**CITY EAST ZONE SUBSTATION &
INTEGRATED COMMERCIAL DEVELOPMENT
33 BLIGH STREET**

ACCESS REVIEW

FINAL v2

9 September 2011

DRAWING Stratum Plan - Level 03 Parking

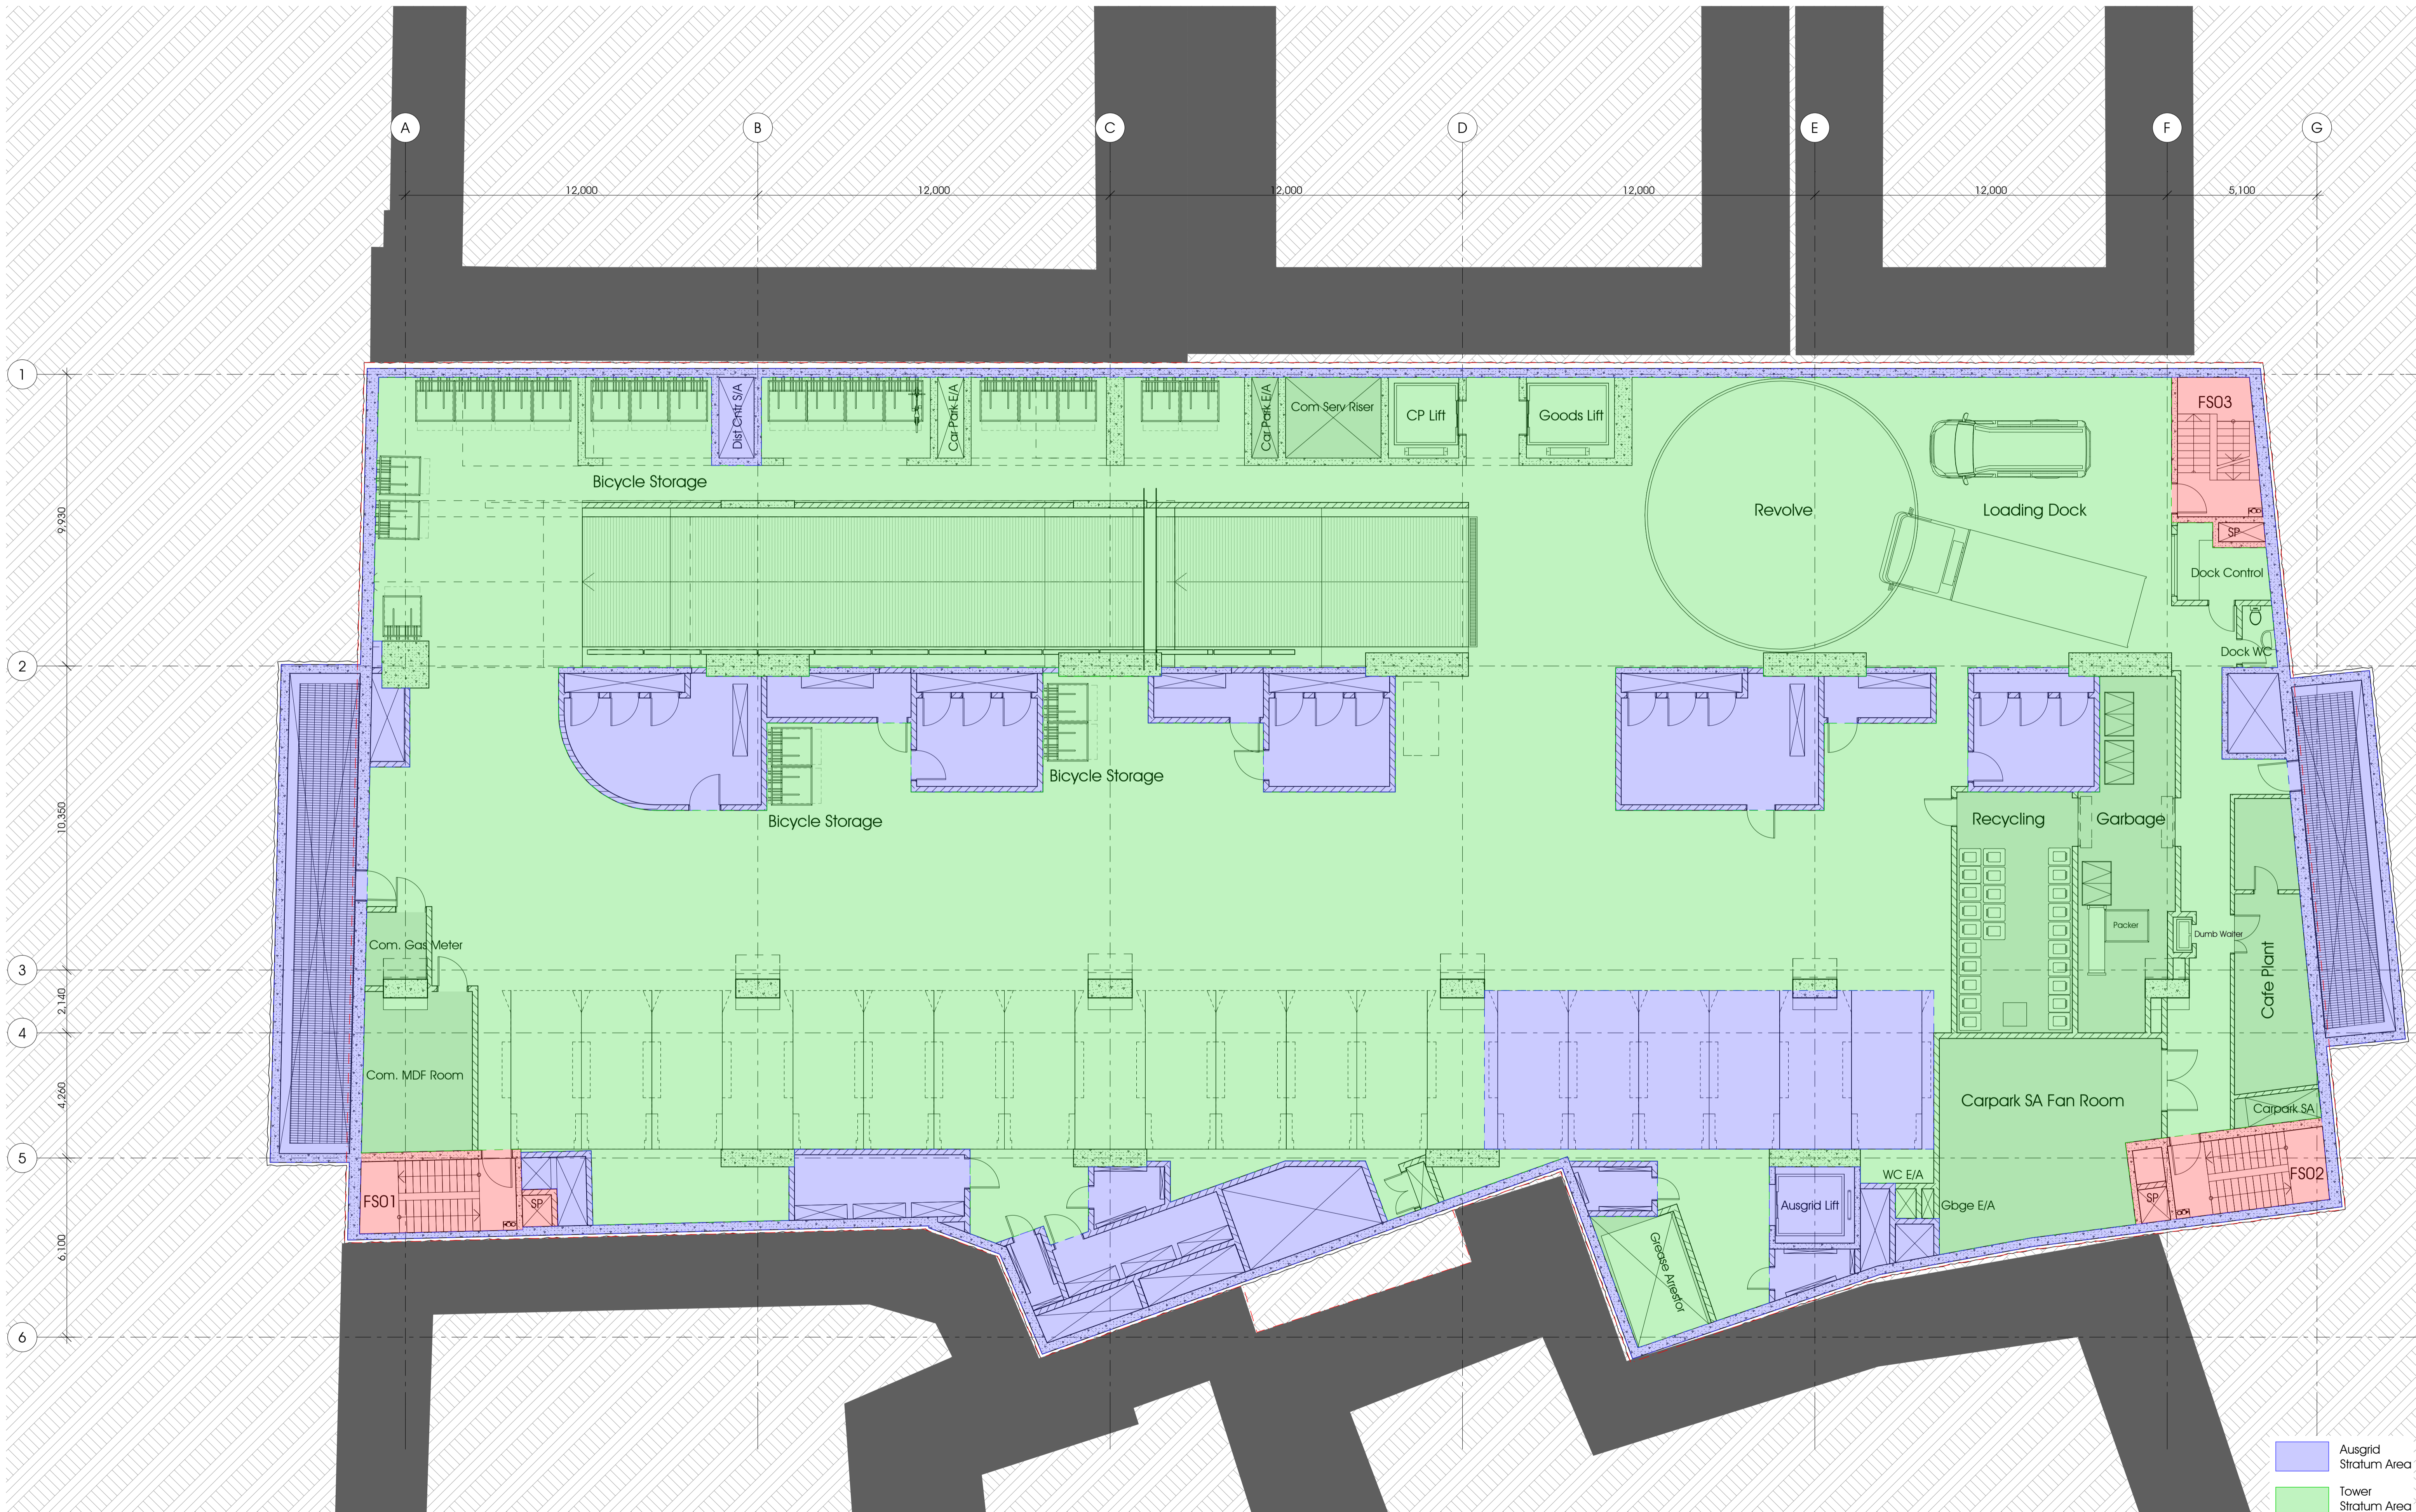
- (i) Provide a bollard at the start of the shared zone.

DRAWING Stratum Plan - Level 14 Sky Lobby

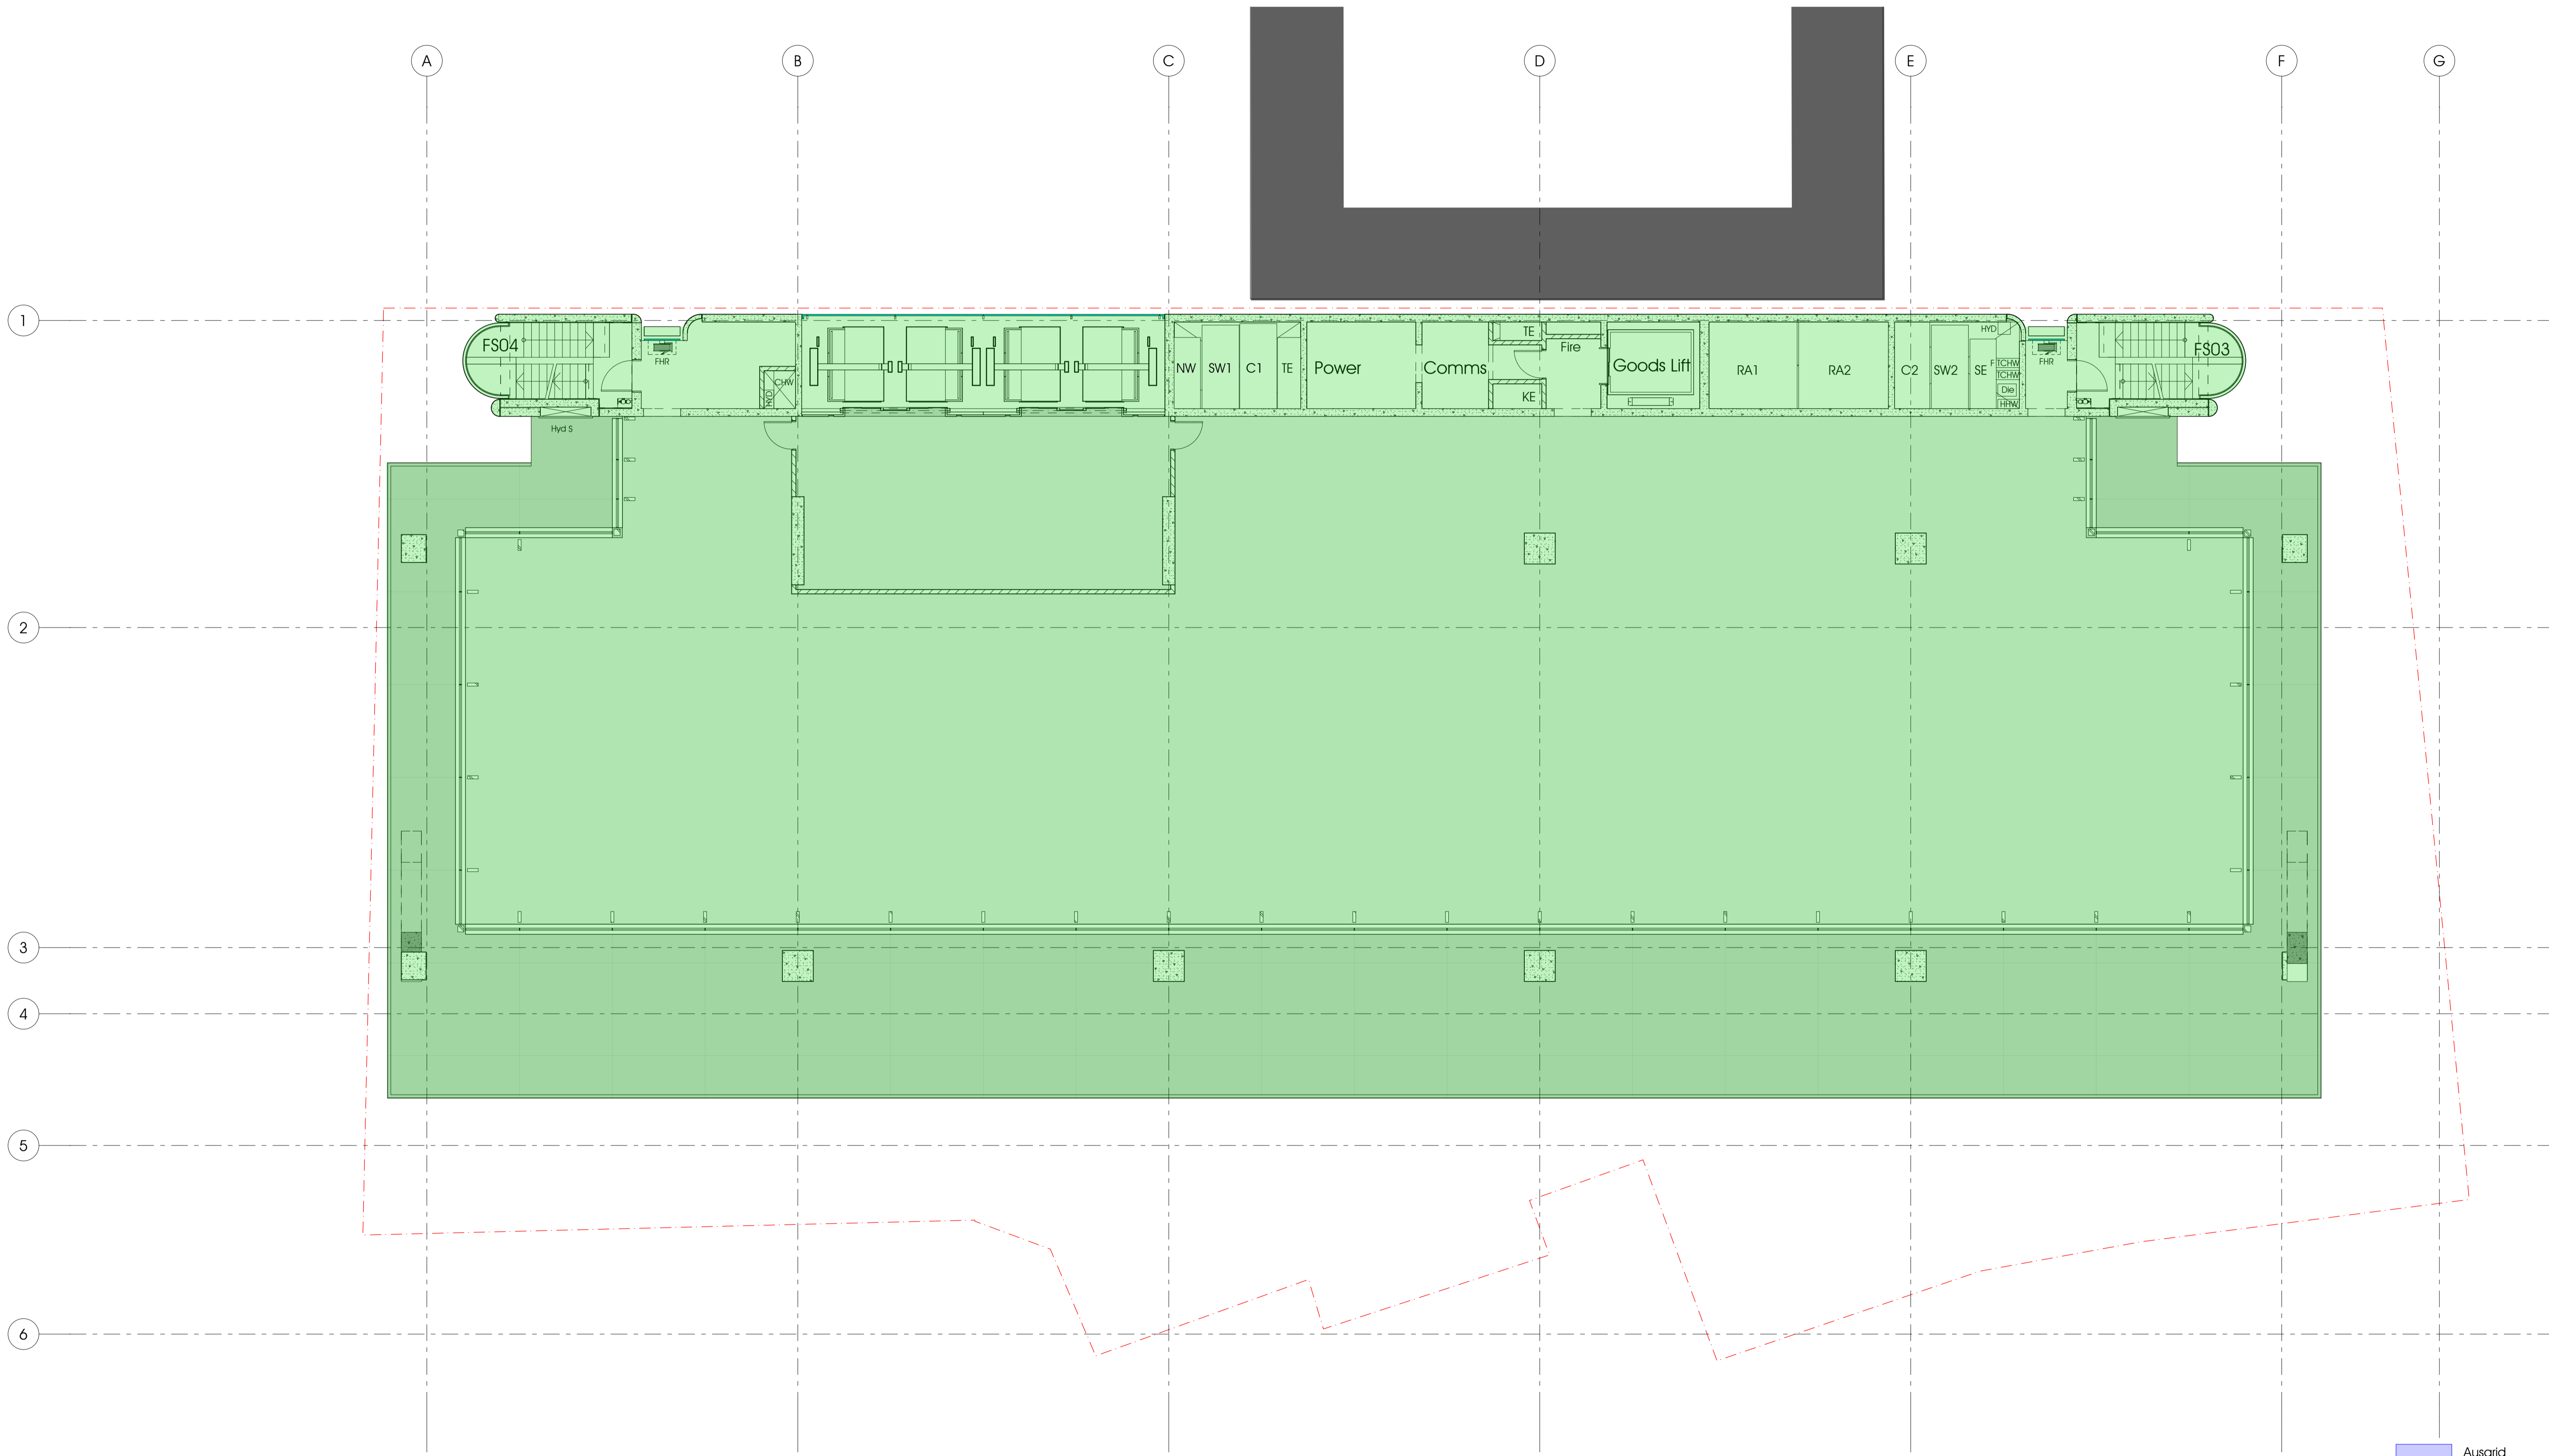
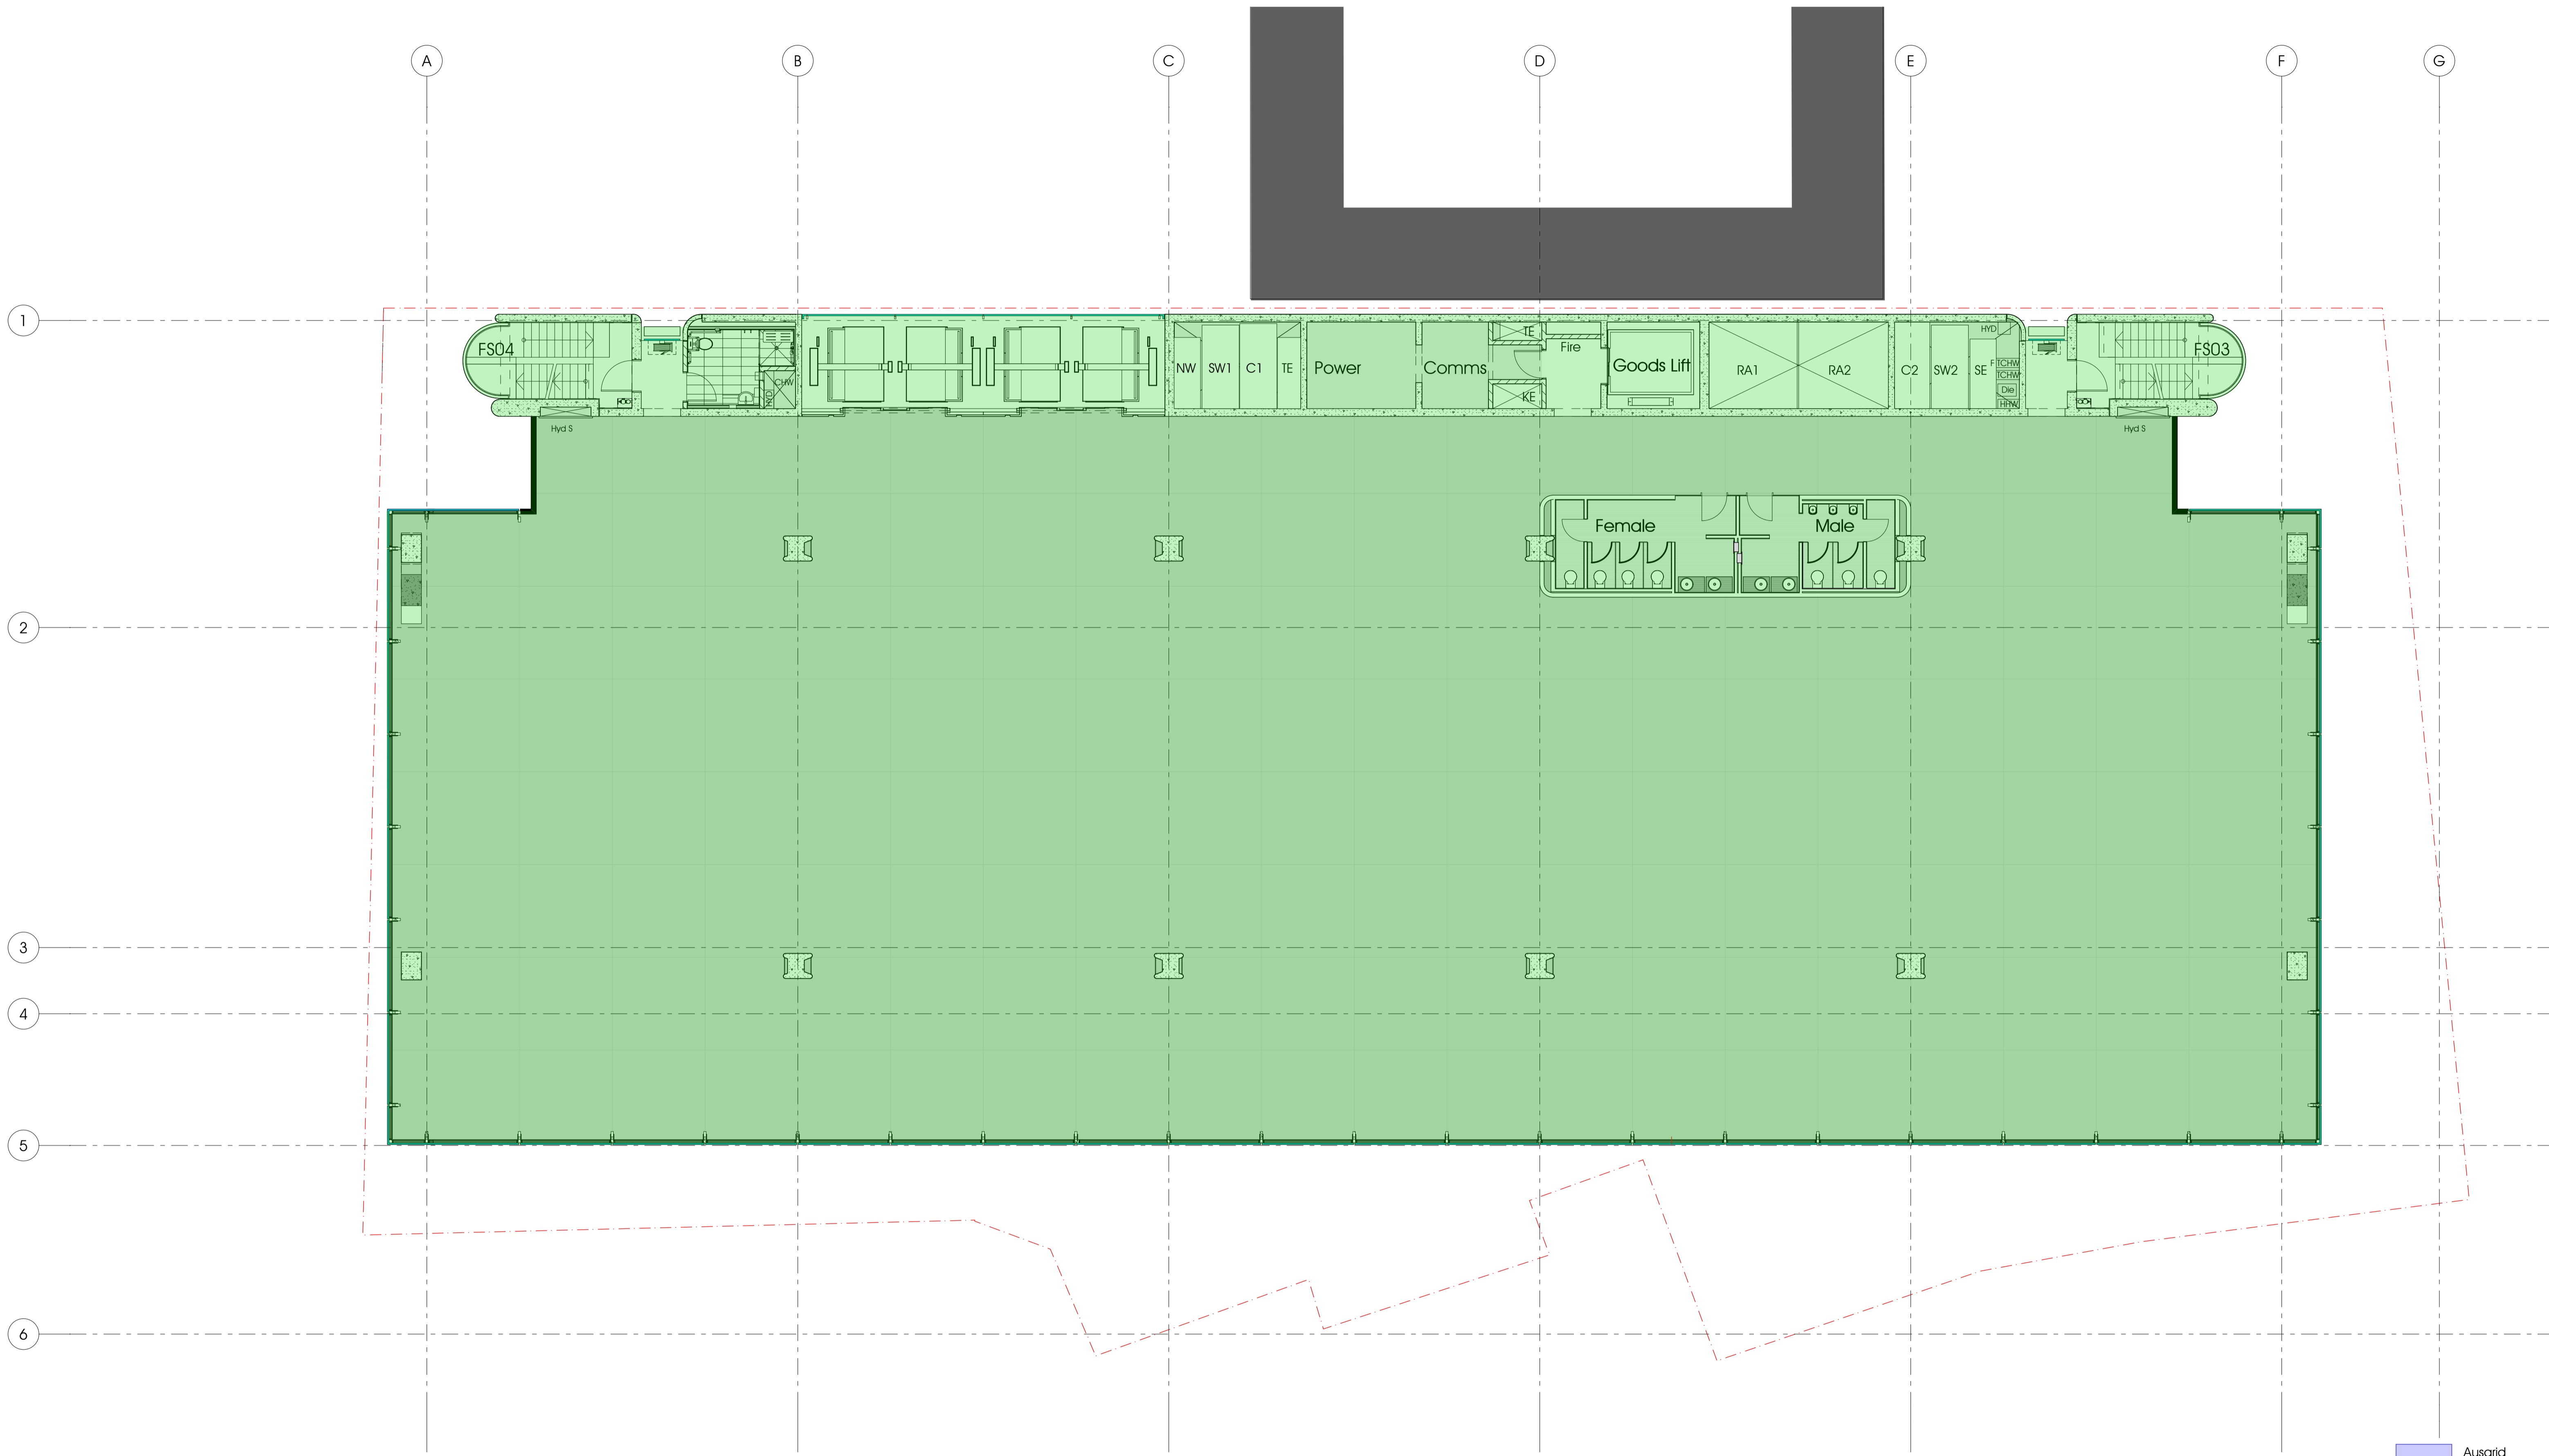
- (i) Ensure the following office and meeting room doors have a minimum 510mm latch side clearance in order to comply with AS1428.1:2009, fig. 31;
 - Level 07, accessible WC: currently none.
 - Level 14, accessible WC corridor door (GZ08): currently 300mm.

There is a stair located on the external seating area of the Sky Lobby. The stairs provide access to the level 13 male and female amenities area.

- (i) Ensure the stairs have closed risers in accordance with AS1428.1:2009.
- (ii) Ensure there are handrails on both sides of the stair compliant with AS1428.1:2009.
- (iii) Ensure there are tactile ground surface indicators (TGSIs) at top and bottom of the stair in accordance with AS1428.4.
